Appeal Decision

Appeal Ref: 6004329

14 Willow Tree Lane, Hayes, Hillingdon UB4 9BB

- The appeal is made under section 78 of the Town and Country Planning Act 1990 (as amended) against a refusal to grant planning permission.
 - The appeal is made by Sunny Singh against the decision of the Council of the London Borough of Hillingdon.
 - The application Ref is 5516/APP/2025/2441.
 - The development proposed is Change of use from Class C3 dwelling house to 7-bedroom/maximum 8 person HMO Use Class Sui Generis.
-

Ground Floor

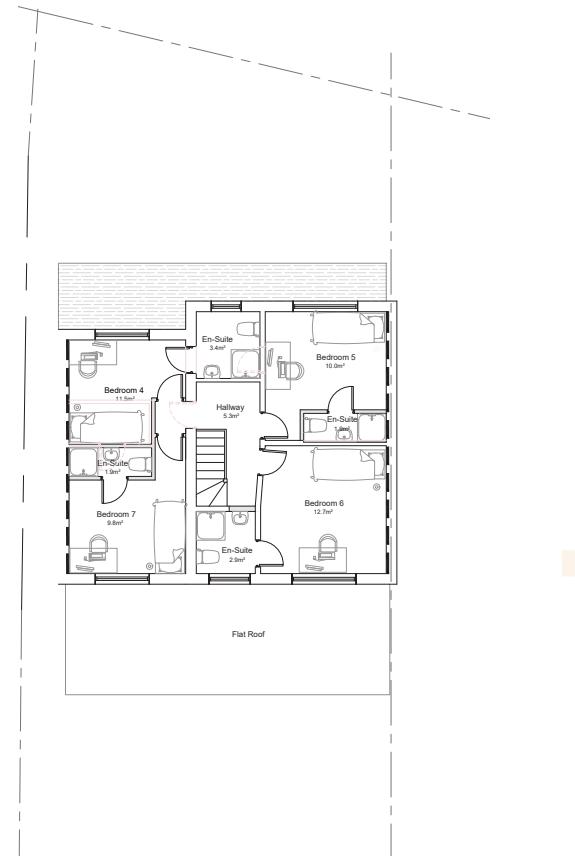
Main Issues

8. The main issues are:
 - the effect of the proposed parking and access arrangements on highway safety,
 - whether suitable living conditions would be provided for future occupiers, having particular regard to the outlook from Bedroom 3 and the proposed outdoor amenity space,
 - the effect of the proposed change of use on living conditions for occupiers of neighbouring properties, with particular regard to noise and disturbance,
 - whether suitable provision would be made for cycle storage,
 - the effect on the character and appearance of the area, and
 - the effect of the proposed change of use on the supply of larger dwellings,

no specific parking standards for large HMOs in the Part Two Local Plan³, with the table in Appendix C stating that car parking requirements will be assessed through a transport appraisal and travel plan. While the Transport Assessment⁴ confirms that two spaces would be provided, that appears simply to reflect the capacity of the hardstanding, rather than any objective assessment of demand. Comparison with the required standard for a C4 HMO use is of limited relevance for this appeal, as that is not the existing use of the site as described in the planning application.

#### EXISTING BLOCK PLAN

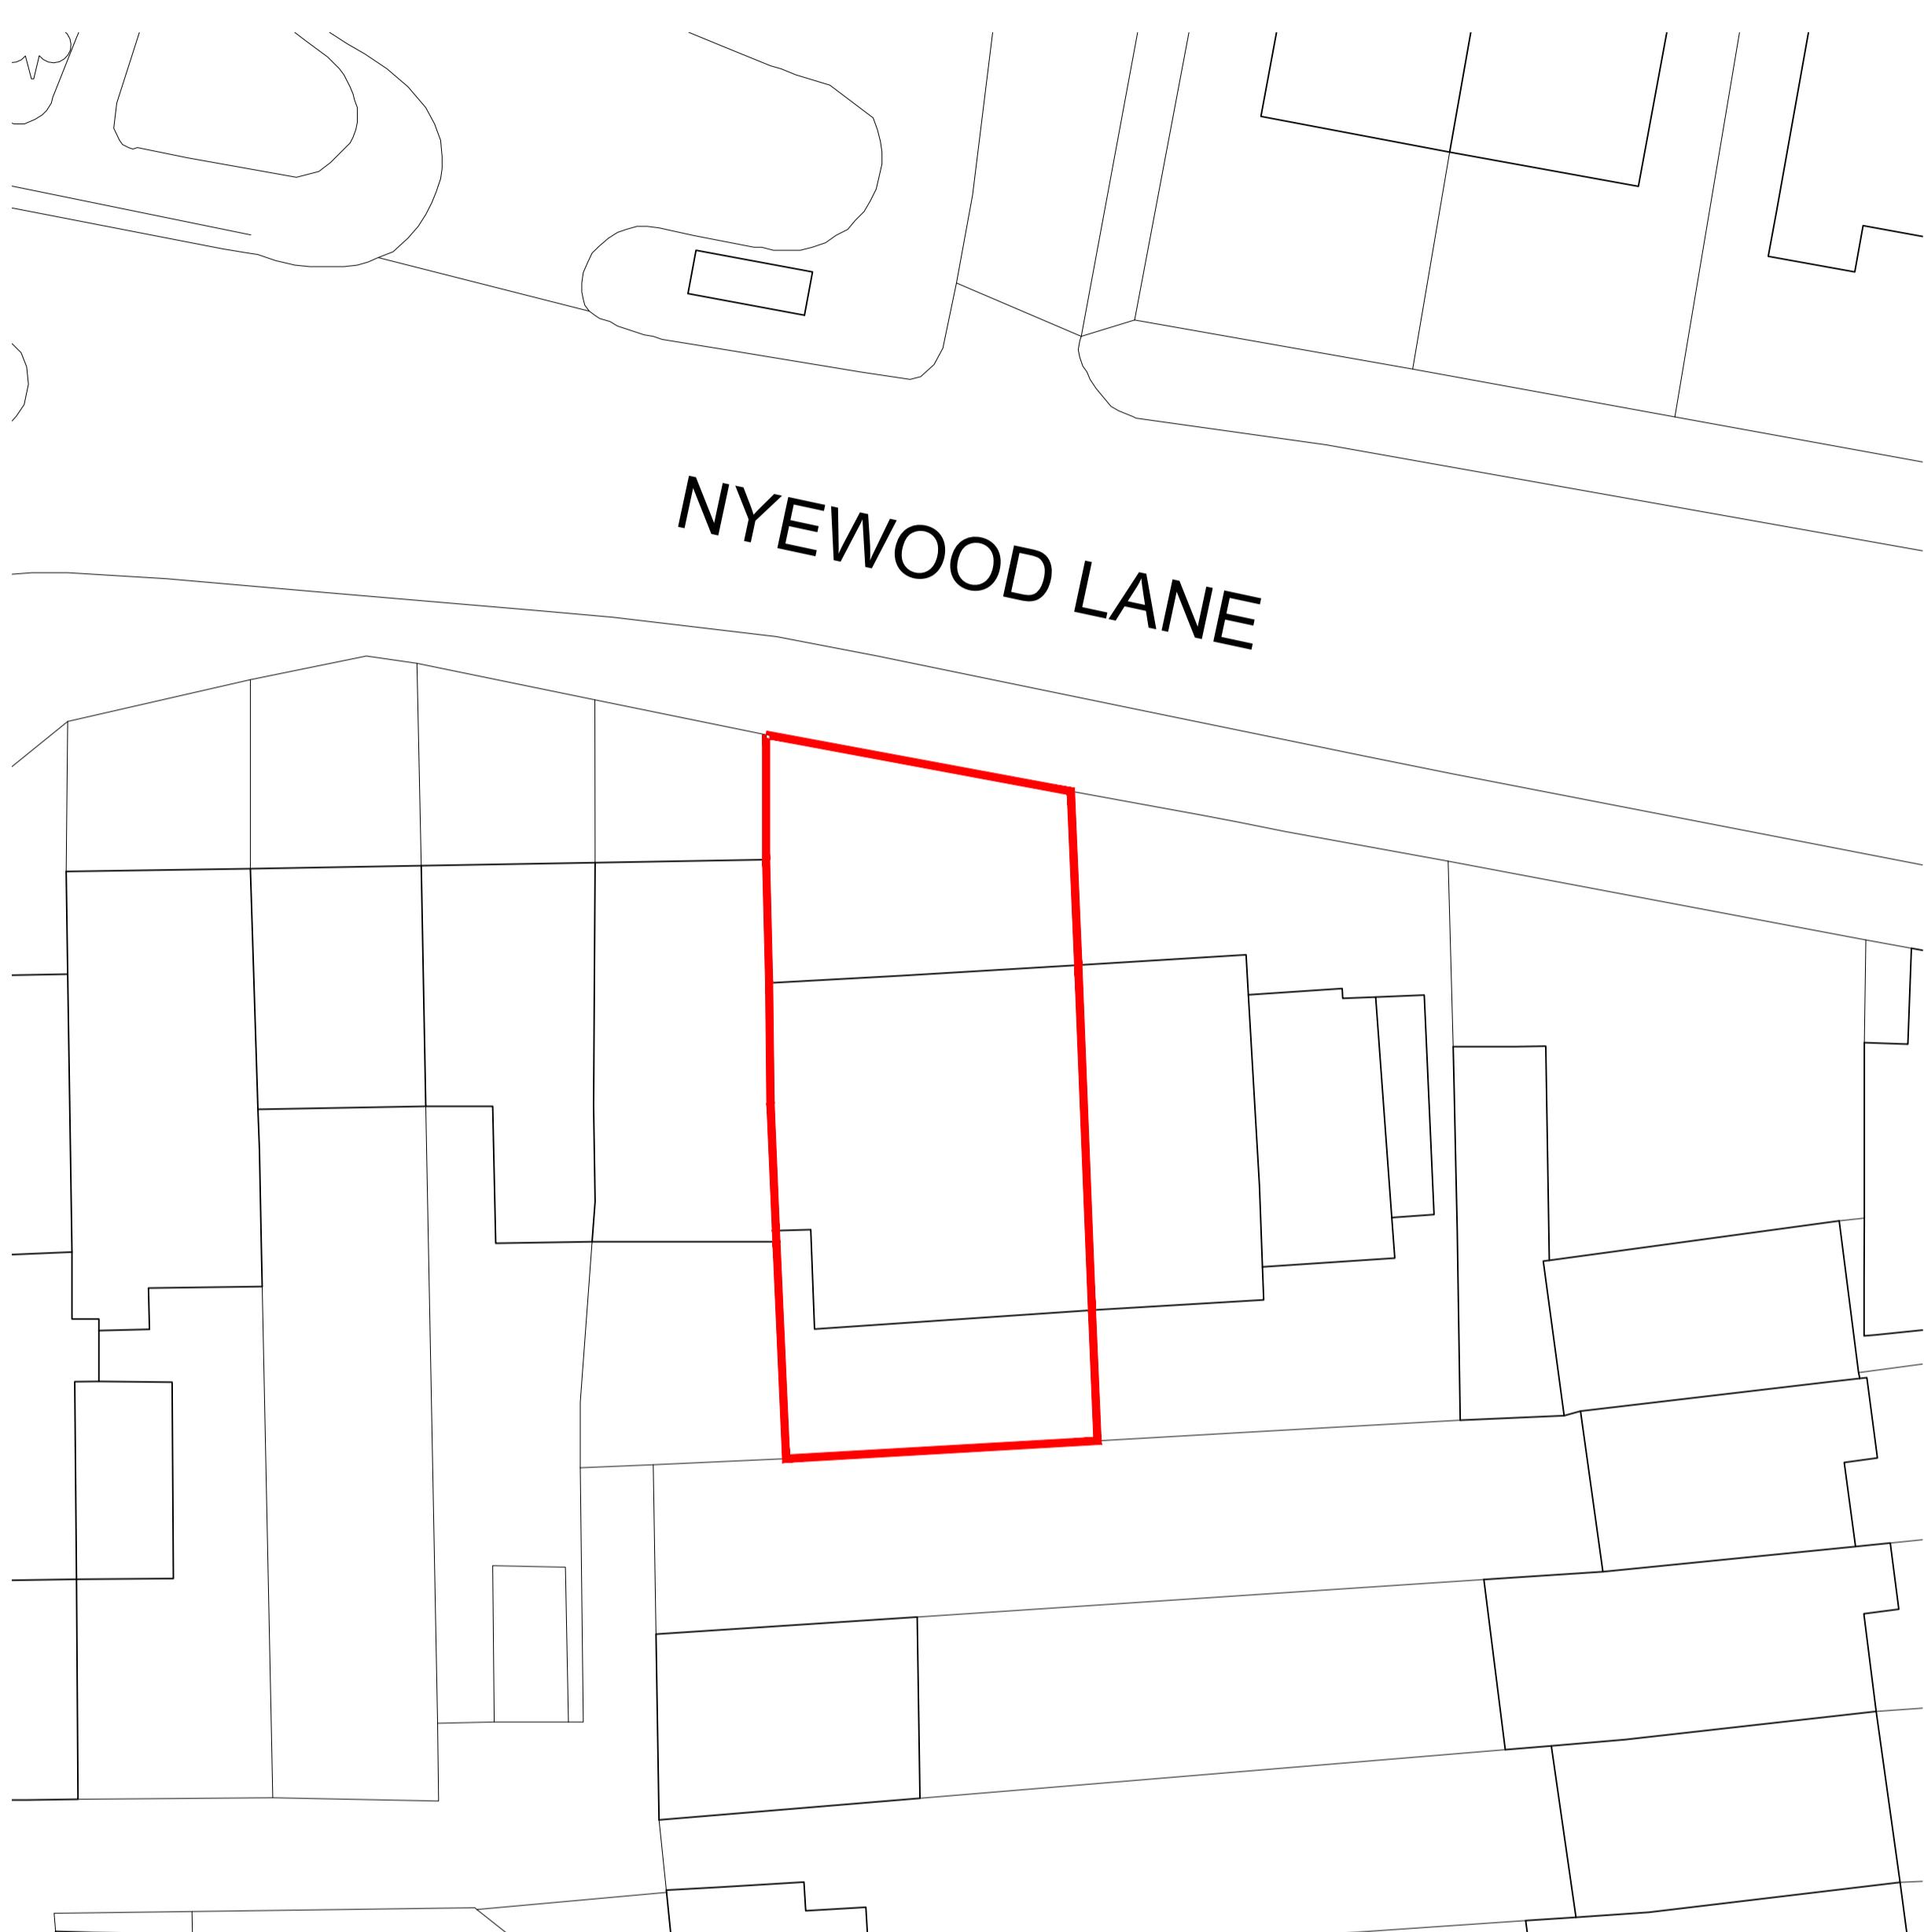
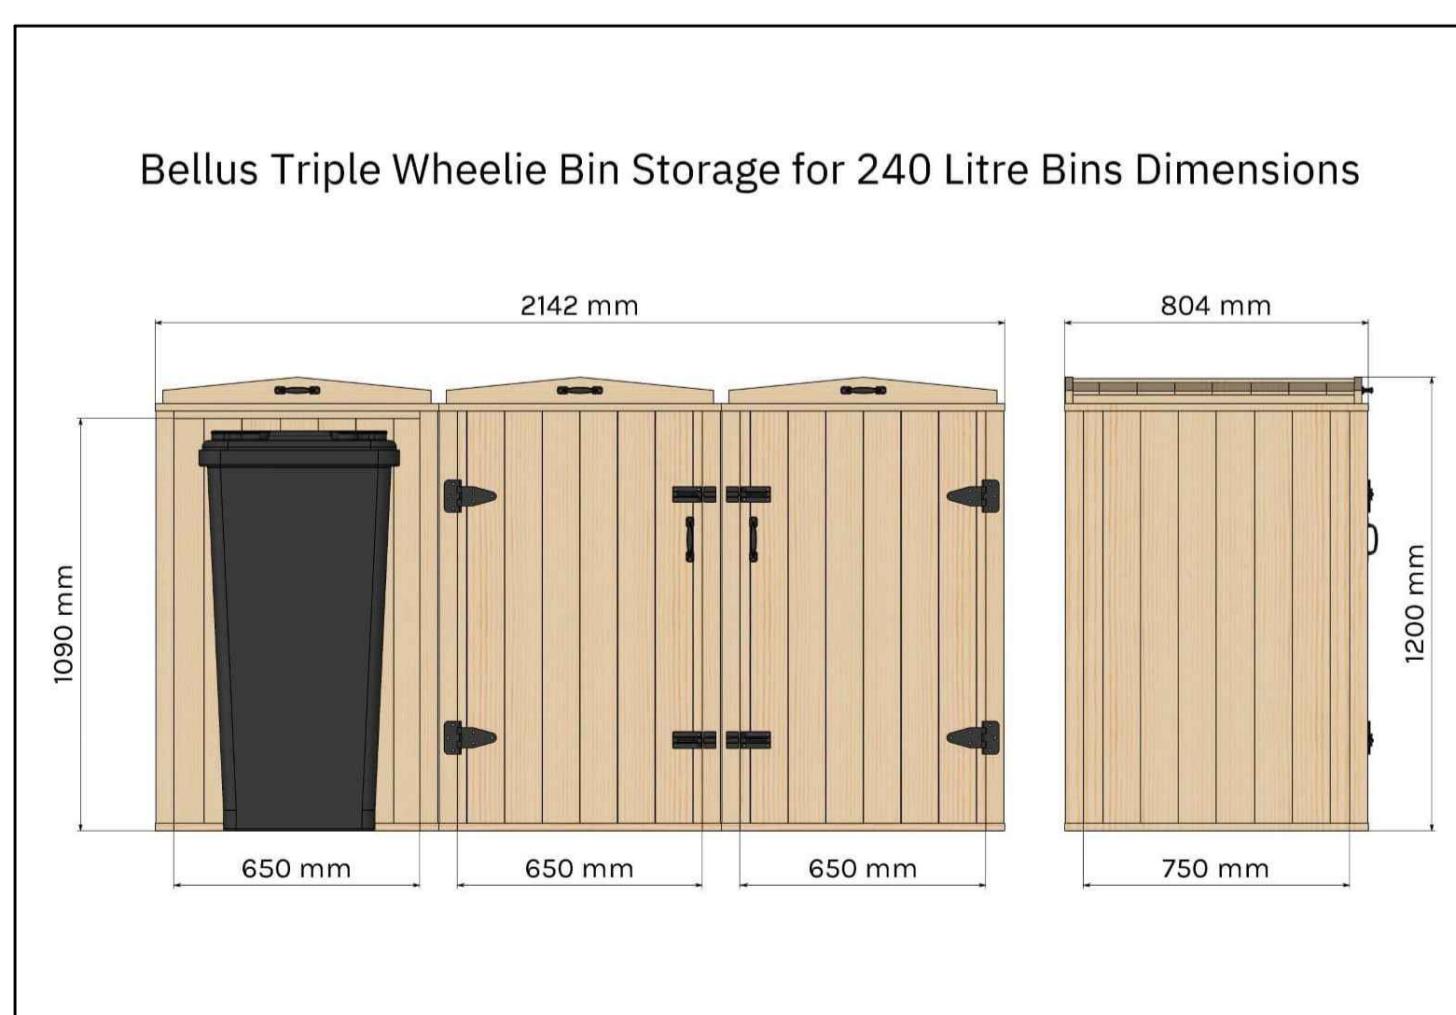
16. Since there would be no turning facilities, that would include additional reversing movements. Based on the swept path details, the siting of the cycle store would only just provide enough tolerance for use of the parking spaces and the Highways Authority has questioned whether adequate clear space would be available in front of the parking bays. That raises the prospect of multiple shunting movements as vehicles negotiate the rather constrained parking layout.

17. In addition to the bus stop opposite, the appeal site is close to the signal-controlled junction of Willow Tree Lane and Yeading Lane, and several other minor junctions and property accesses. Increased use of the access, particularly in reverse, would raise additional risk of conflict between vehicles and pedestrians within this relatively complex highway environment. That would particularly be the case when buses stop opposite and/or traffic is queued at the lights. Cars parked directly outside the appeal site could also impact visibility for those using the access.

18. Although the number of accidents reported in the Crash Map data is small, three of them were in the immediate vicinity of the site, and the fourth was only very slightly further away. The accident descriptions include interactions between cars and buses leading to personal injury and, in one case, a parked car was described as having affected pedestrian visibility. They are low speed incidents which did not cause serious injuries, and the accident records do not appear to be indicative of an inherently dangerous highway layout. However, they do provide evidence of conflict between road users, including pedestrians. The likelihood of such incidents, and possibly their severity, would increase with more intensive use of the access, in combination with increased on-street parking outside the site.

#### PROPOSED BIKE STORAGE UNIT

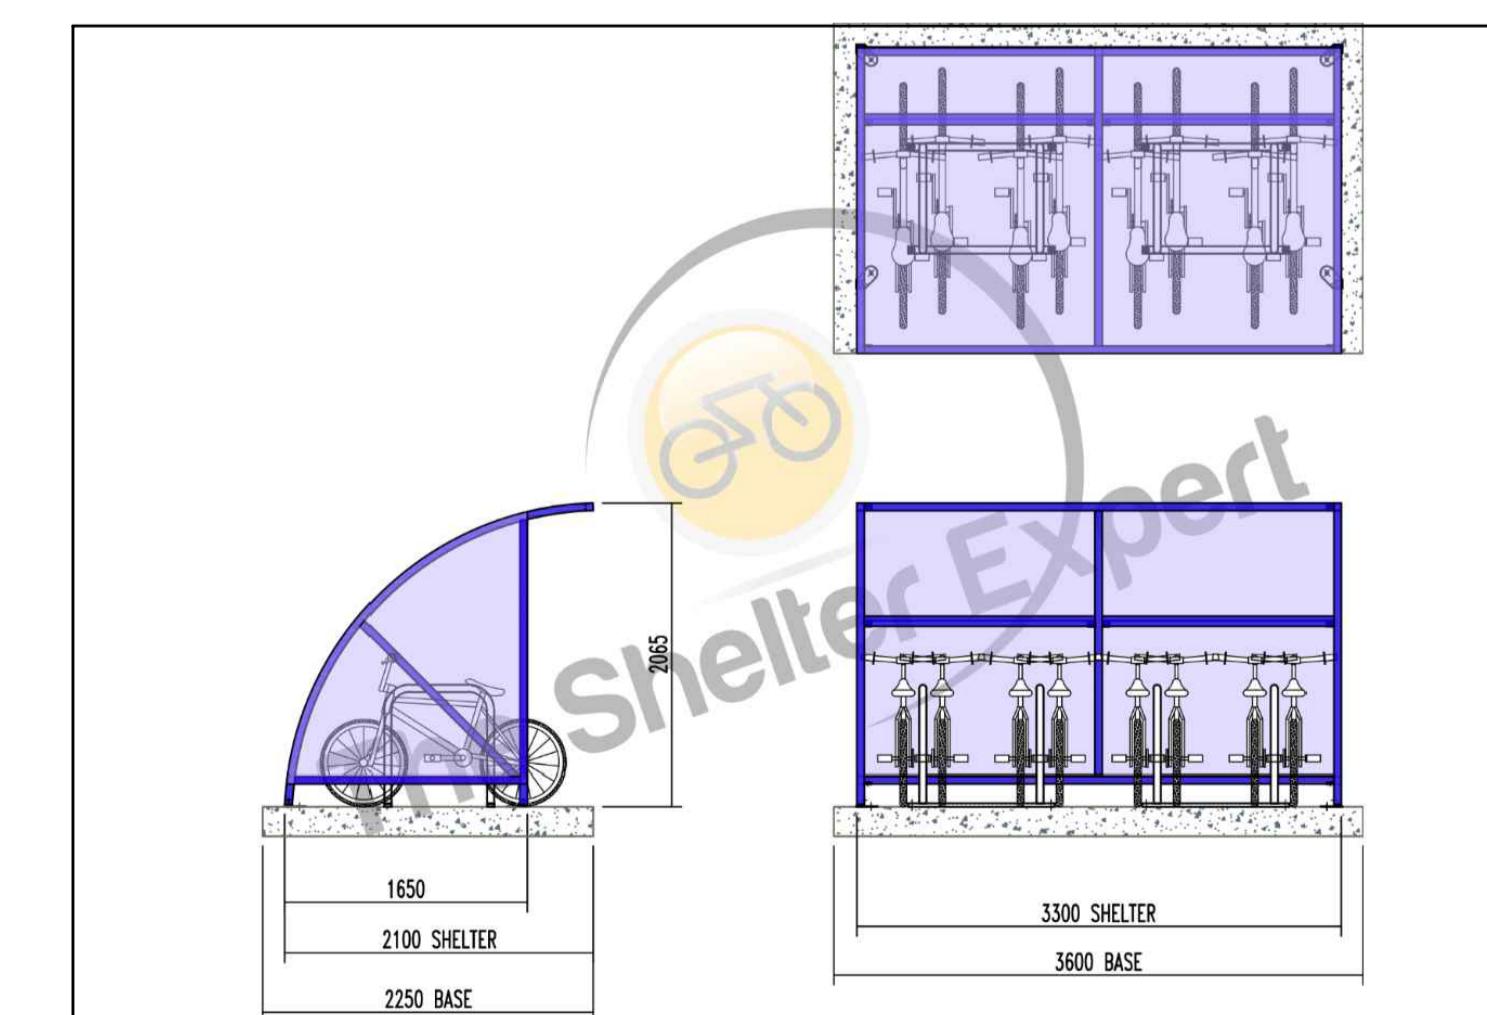
35. Storage for eight cycles is proposed, which would accord with the minimum numerical standards in London Plan Policy T5 and Policy DMT5/Appendix C of the Part Two Local Plan. The proposed Block and Location Plan drawing includes

details of the proposed cycle shelter, to be sited within the front driveway. It would be open fronted, but covered for weather protection, and would be conveniently located close to the front door in an easily monitored position, where there is street lighting nearby.

36. As previously noted, the cycle store would be only just clear of the swept path for vehicles arriving and departing and that is a factor in the highway safety concerns. Linked to that, there is some risk that users of the cycle store would be inconvenienced by the arrival and departure of motor vehicles, and that would be at odds with the requirements in the London Cycle Design Standards (LCDS) that cycle storage is fit for purpose and well-located for use by the occupants. However, any such interactions would be at low speed and there would be space for cyclists to stand clear of arriving and departing vehicles. Based on the evidence before me, despite the relatively constrained layout, it appears that these two uses could co-exist with a reasonably foreseeable level of care and consideration between occupiers.

39. When considering the effect on the character and appearance of the area, the Council's Officer Report suggested that the cycle store could be at the rear, but that is not the layout shown on the plans. Sited as proposed, the cycle store would be clearly visible from the street and a facility of the scale and nature proposed would not typically be found at a family dwelling. Nevertheless, no specific objection has been articulated by the Council to the design, siting or appearance of the cycle store. It would be a relatively modest structure, backing on to the projecting flank wall of the neighbouring property, which would provide some screening. The immediate surroundings also include commercial uses and a variety of street furniture and within that context it would not be an unduly prominent or alien feature in the street scene.
